Rezoning Transportation Analysis

Petition Number: 2021-118

Revision Log:

Date	Description
09-23-2021	First Review (KP)

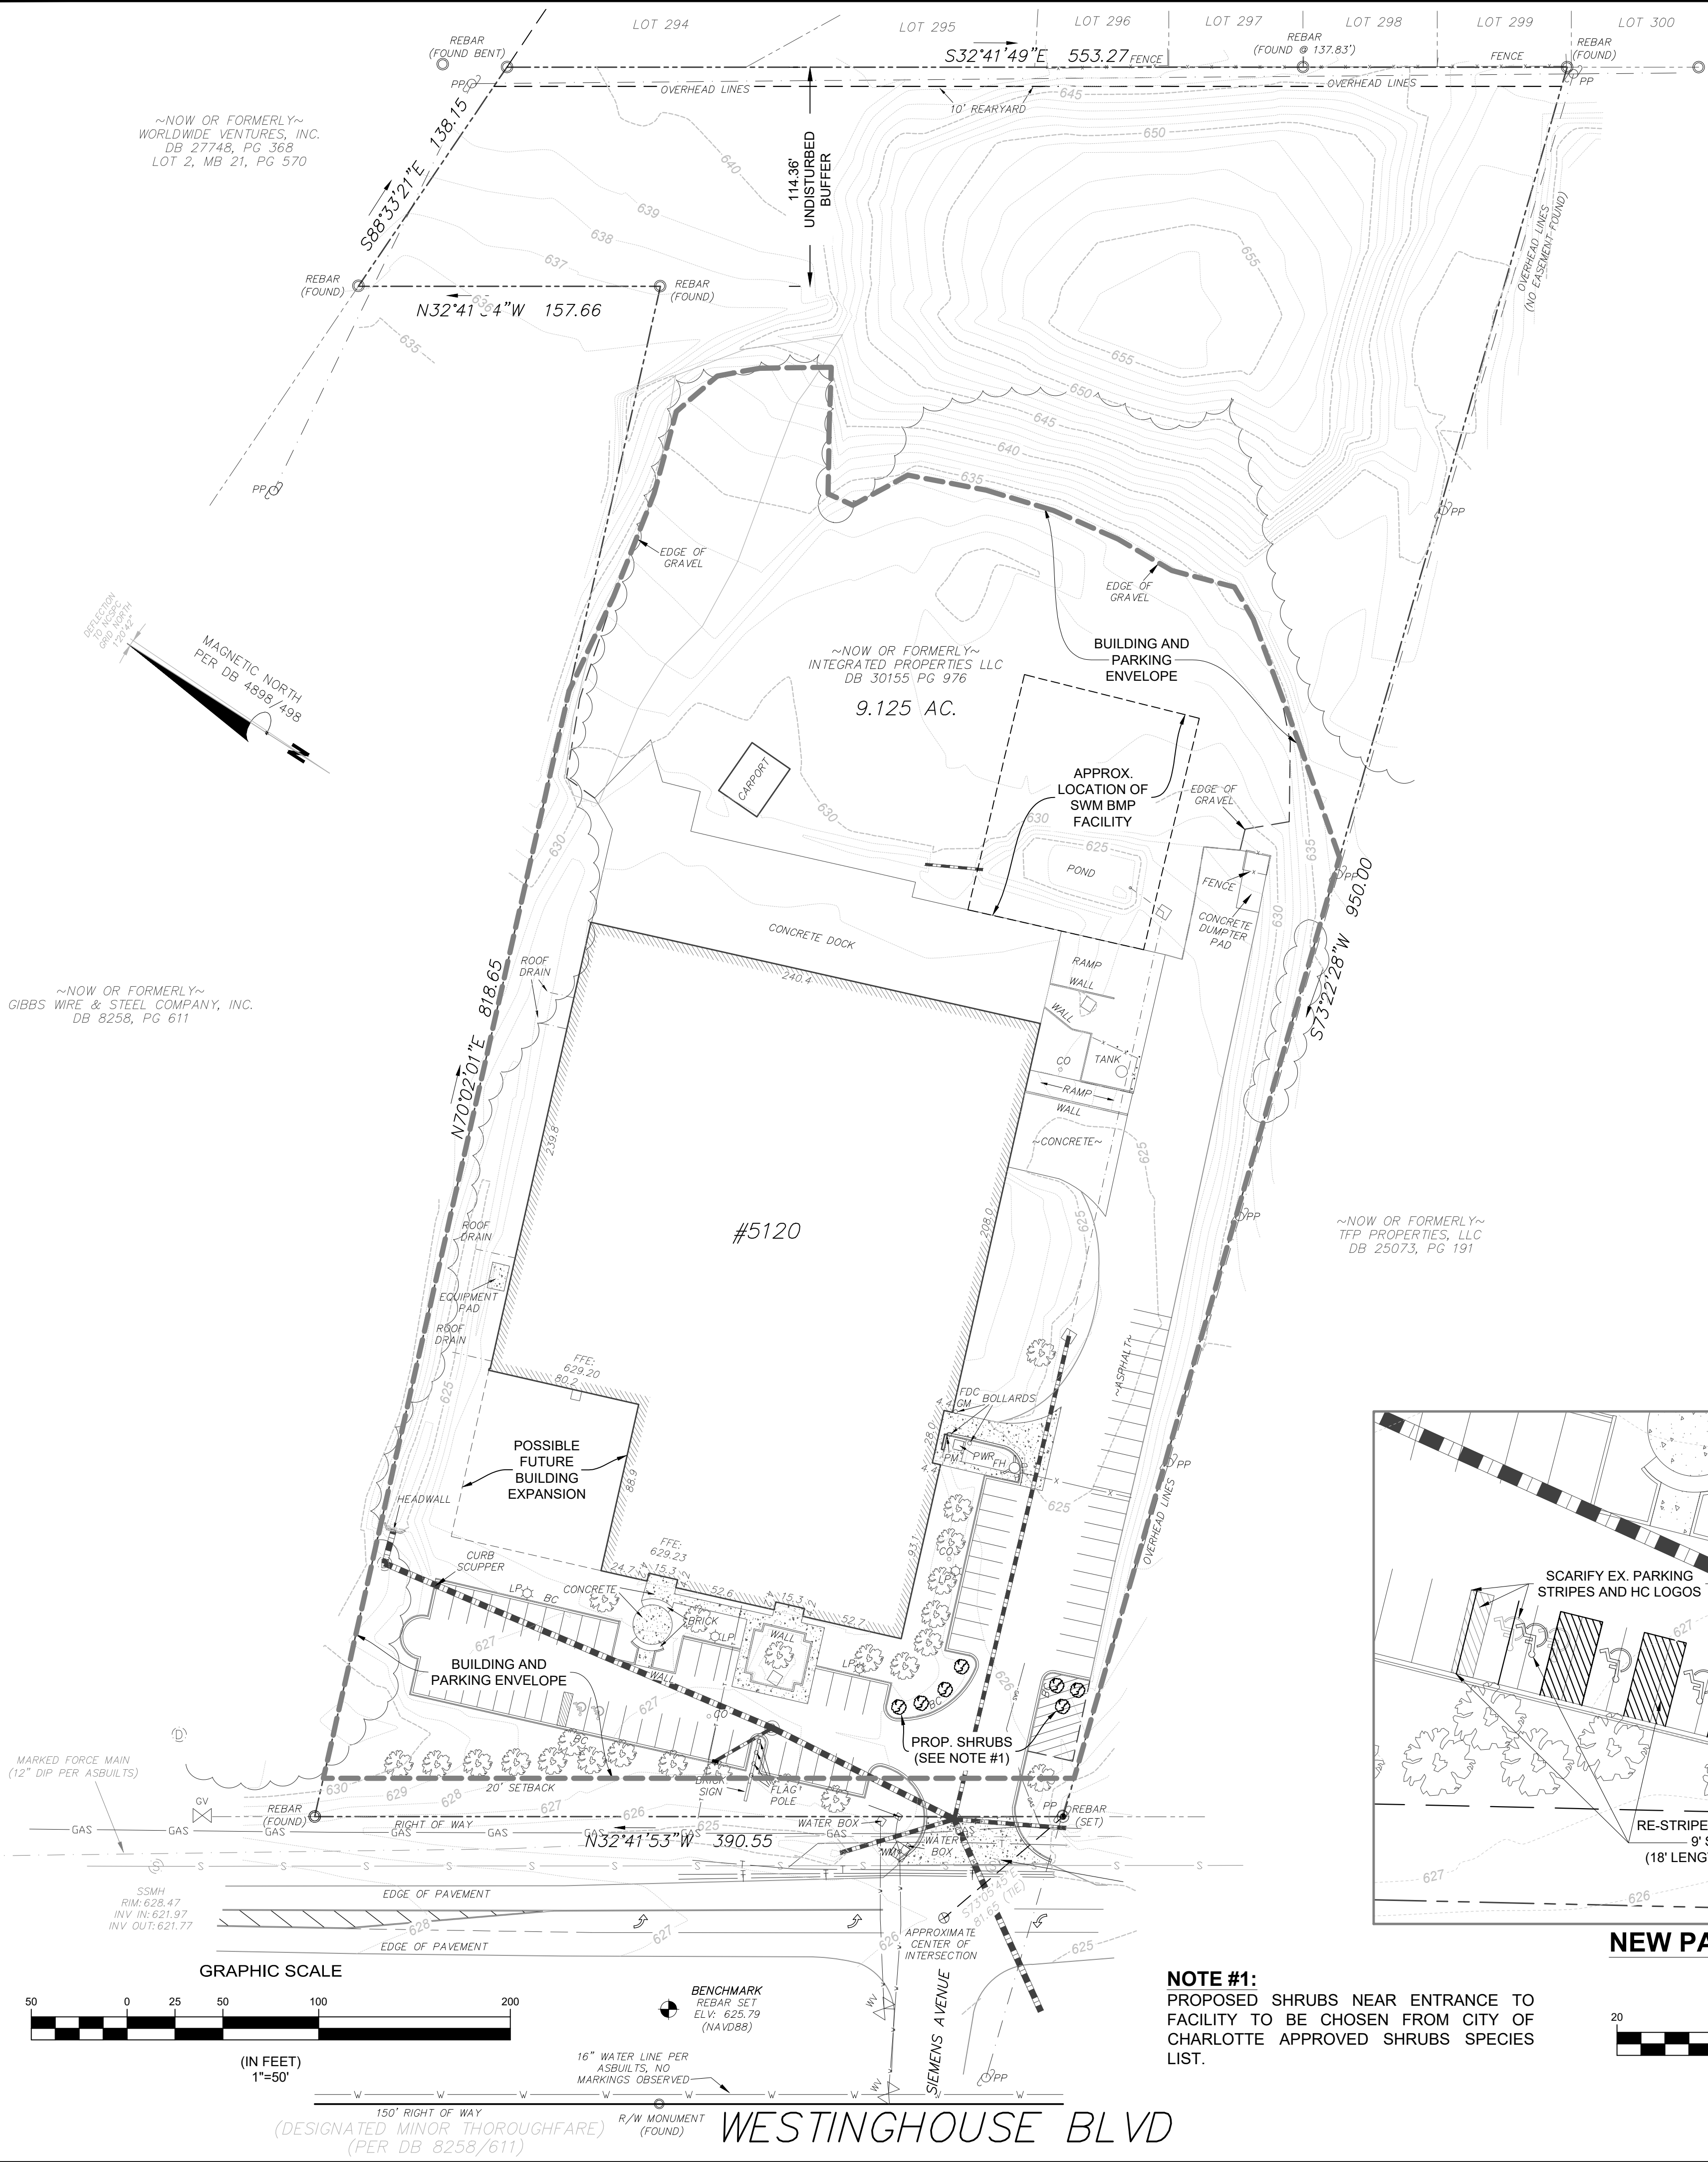
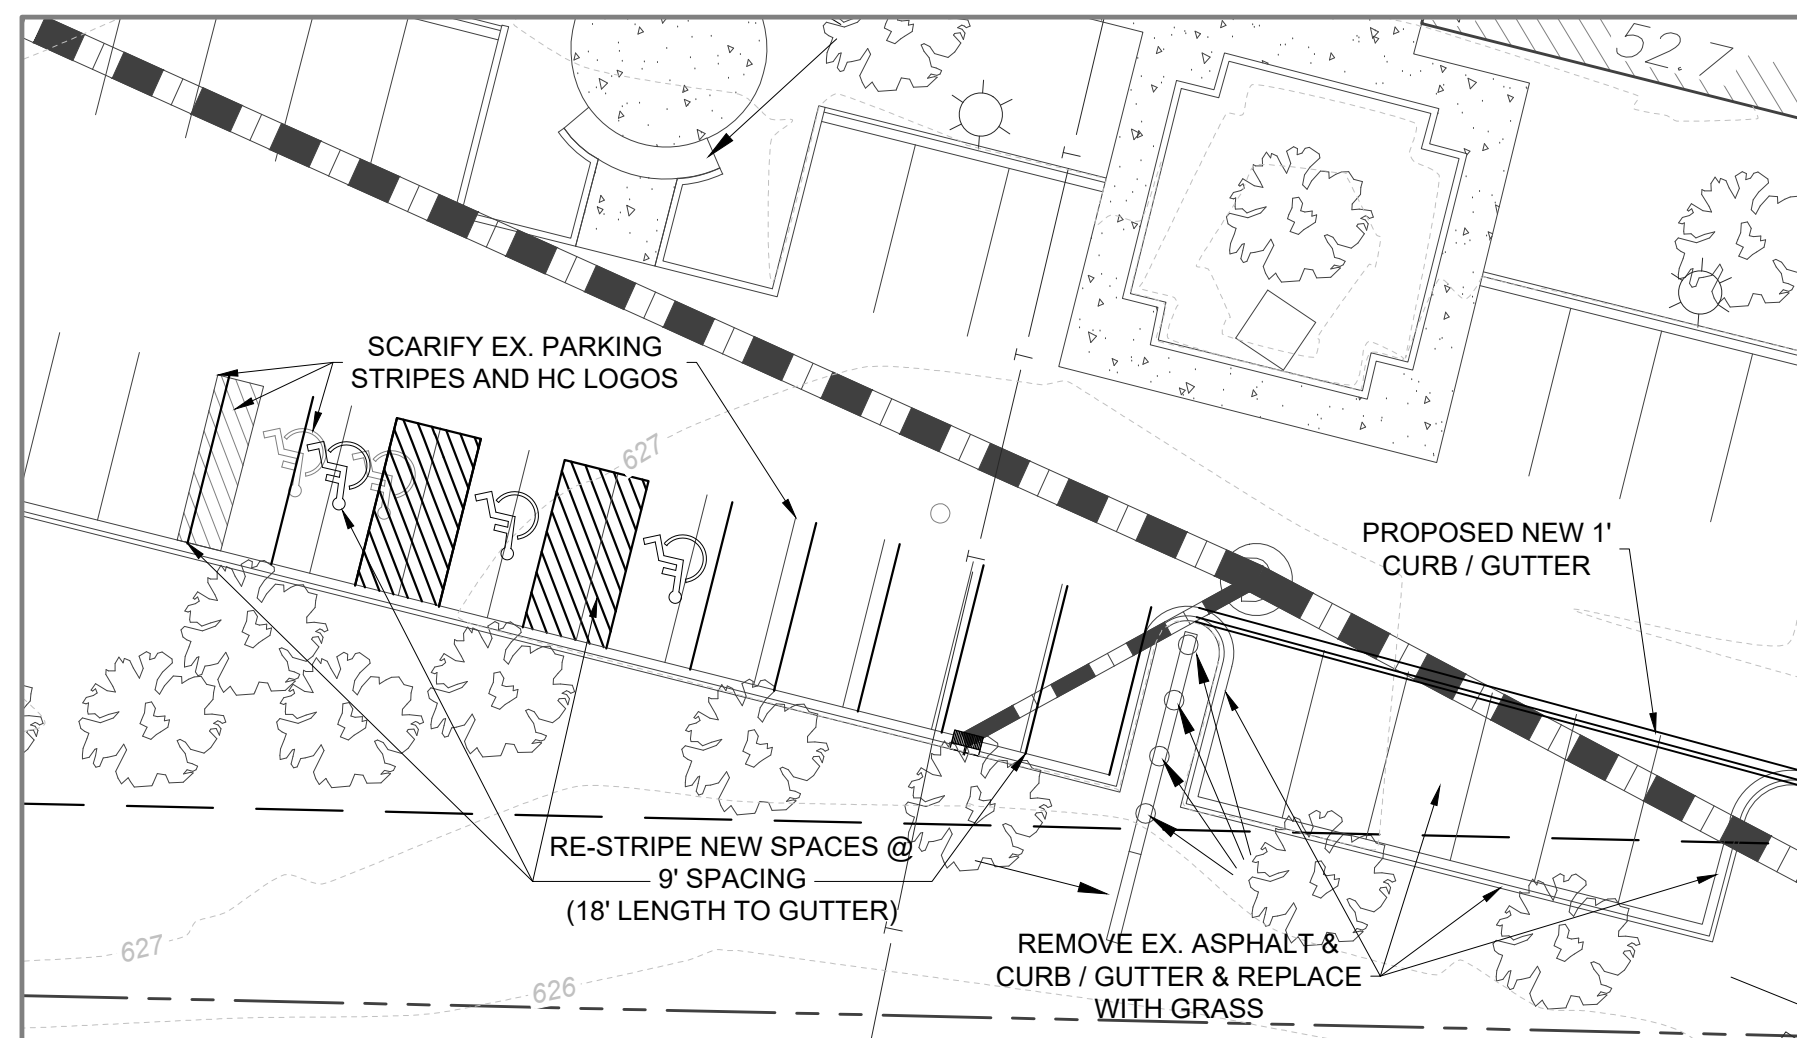
- Curb line:** The proposed zoning district has a setback measured from back of the existing or proposed future curb line.
 - Westinghouse Boulevard:** Curb and gutter is not required with this petition; however, the future location of curb and gutter will be 30-feet from the existing centerline measured to the back-of-curb.

Label and dimension the future back-of-curb from the existing centerline.

- Revise site plan and conditional note(s) to commit to dedicate 52-feet of right-of-way from the existing centerline of Westinghouse Boulevard. The site plan shall label and dimension the right-of-way from the road centerline.
- Revise site plan and conditional note(s) to commit to construct an 8-foot planting strip, and 12-foot shared-use path along the site's frontage of Westinghouse Boulevard. This shared-use path shall be placed relative to the future curb line location, noted in outstanding issue 1.a, and appropriate ADA curb ramps will be provided across the existing driveway. The site plan shall label and dimension the shared-use path from the existing road centerline.

- Revise site plan and conditional note(s) to commit to coordinating with the City of Charlotte and NCDOT, during permitting, to provide a pedestrian crossing across Westinghouse Boulevard and

provide a connection to the City's Westinghouse Boulevard Multi-use Path Capital Improvement Project. This pedestrian crossing will provide the appropriate curb ramps and components to provide ADA and PROWAG accessibility. Additionally, a direct and logical internal pedestrian connection will be provided from the shared-use path to the site.
